WEST SUSSEX COUNTY COUNCIL CONSULTATION

TO:	Arun District Council FAO: Anita Gardner
FROM:	Alison Meeus, Highways, WSCC
DATE:	08/05/2018
LOCATION:	Land East of Windy Ridge, Mayflower Way
SUBJECT:	12 social dwellings for Angmering Community Lnad Trust, including two communal bike stores, a pedestrian mews, and orchard. Departure form the development plan.
DATE OF SITE VISIT:	08/05/2018
RECOMMENDATION:	☒ Advice ☐ Objection ☐ Modification ☒ No Objection ☐ More Information ☐ Refusal
S106 CONTRIBUTION TOTAL:	£ See below for breakdown.

1. Substitute Detailed Site Plan (dwg 201, rev02)
2. Substitute Location Plan (dwg 001 rev 1)

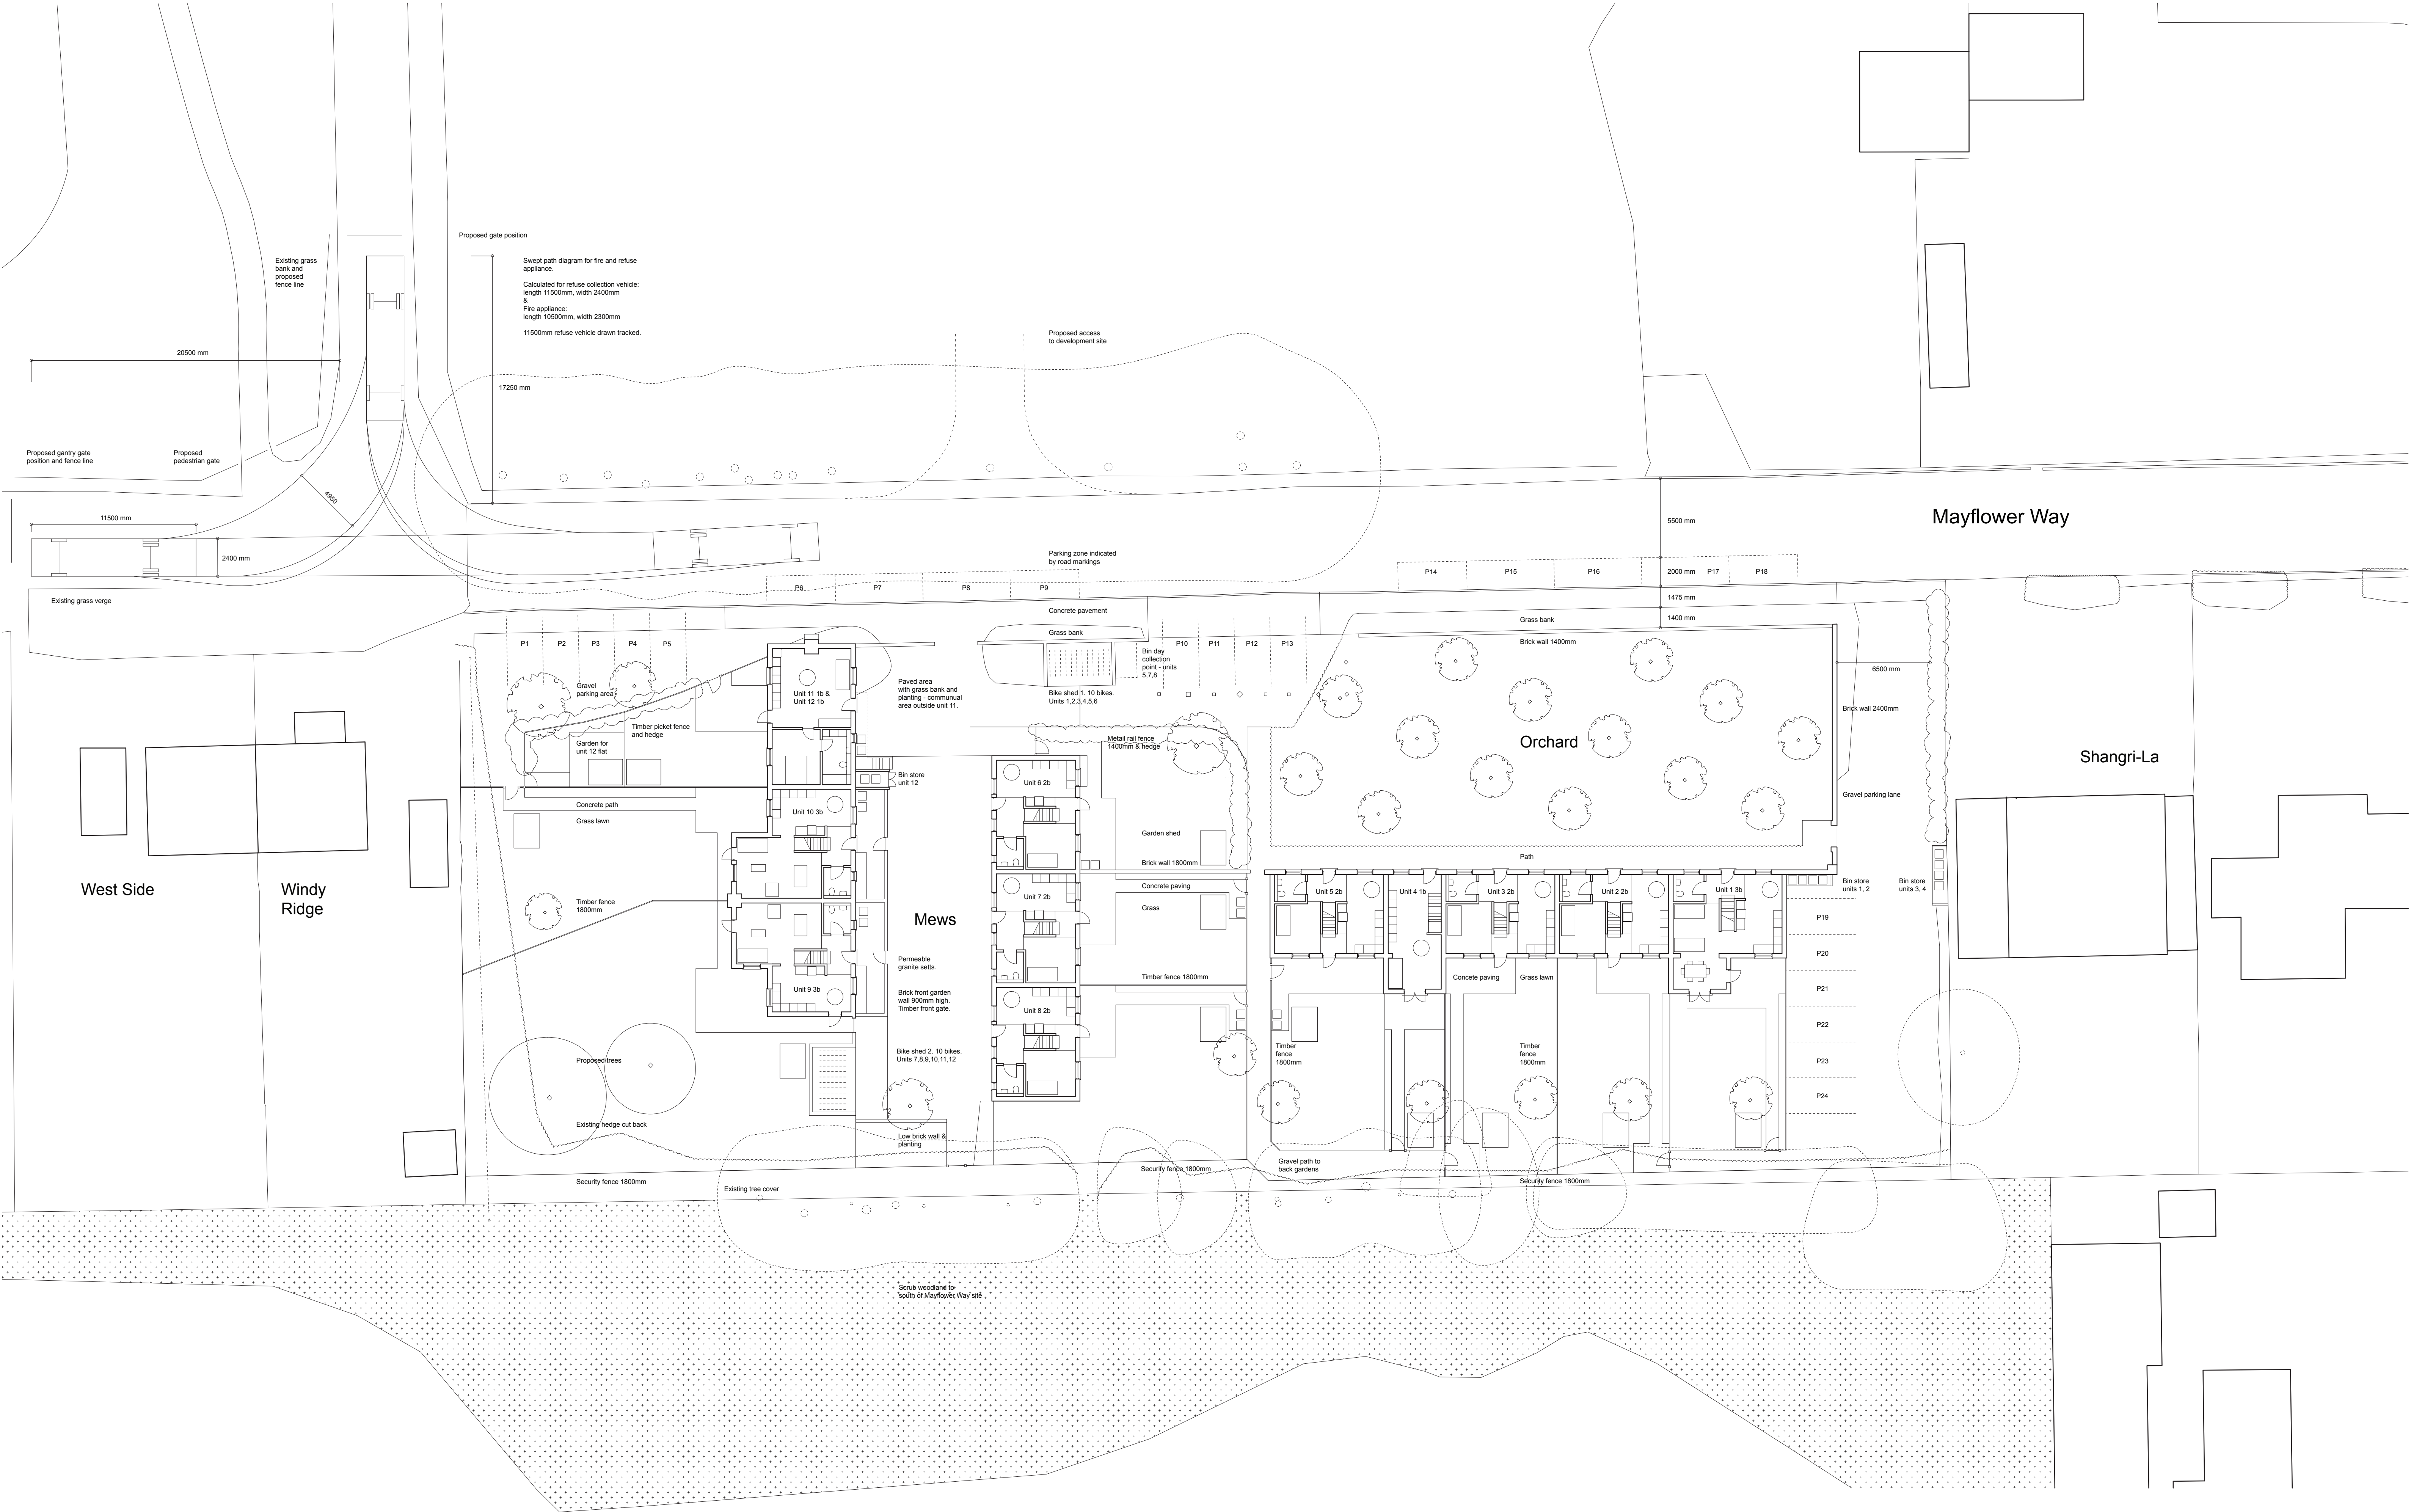
The CHA has considered the additional plan provided by the applicant. The extension of the site area will provide the development with certainty over the proposed car parking for the development, on the section of private road.

The turning head for the fire/refuse appliance will now also form part of the development proposal and will not be subject to any changes, which otherwise may have been out of the applicants control.

No objection.
